**Office of
Environment
& Heritage**

DOC16/231218
SSI 7400

Sydney Metro - Chatswood to Sydenham (SSI 7400)

Attachment 1: OEH comments on Sydney Metro – Chatswood to Sydenham (SSI 7400)

Figure 21-3 Marrickville dive site - change in flood level as a result of the project in the 100-year average recurrence interval event

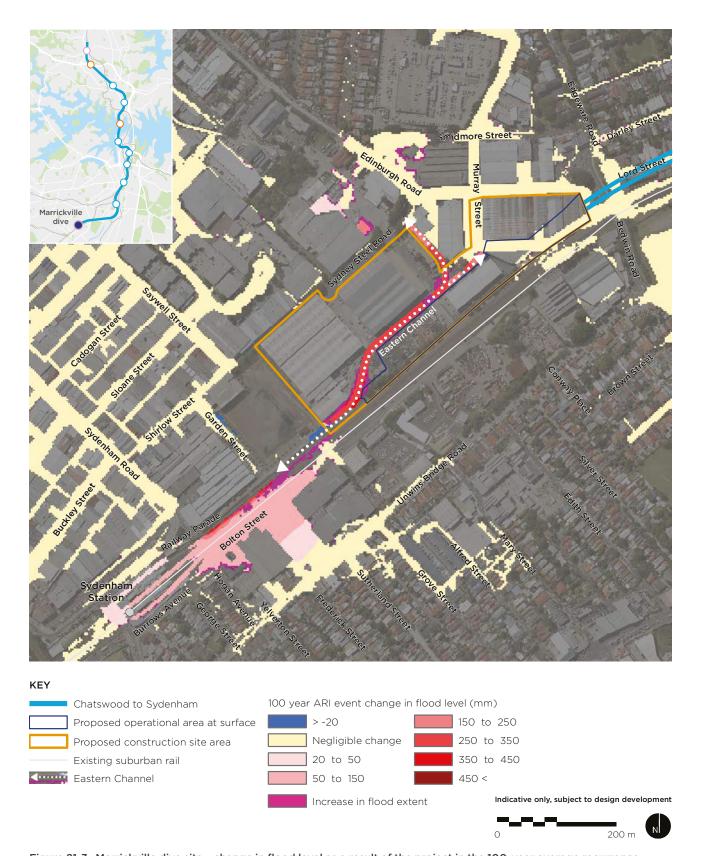
The EIS's Table 21-6 shows that within private property (corner Hogan Avenue and Bolton Streets, Sydenham) there is an increase in flood depth by the proposed development of 70mm for the 100year ARI event and 380mm for the PMF event. There are no figures showing the flood level, extent and velocity differences from the existing terrain compared to that which incorporates the proposed infrastructure or proposed mitigation works and the floor levels of impacted properties.

There is inadequate information provided to assess the impact of the project on flooding on surrounding and downstream areas and to allow OEH to comment on the EIS page 836 conclusion that: *"Given that the increase in flood levels would only occur at areas already subject to flooding, the project would not require changes to existing community emergency management arrangements for flooding and there would not be increased social and / or economic costs to the community as consequence of flooding"*.
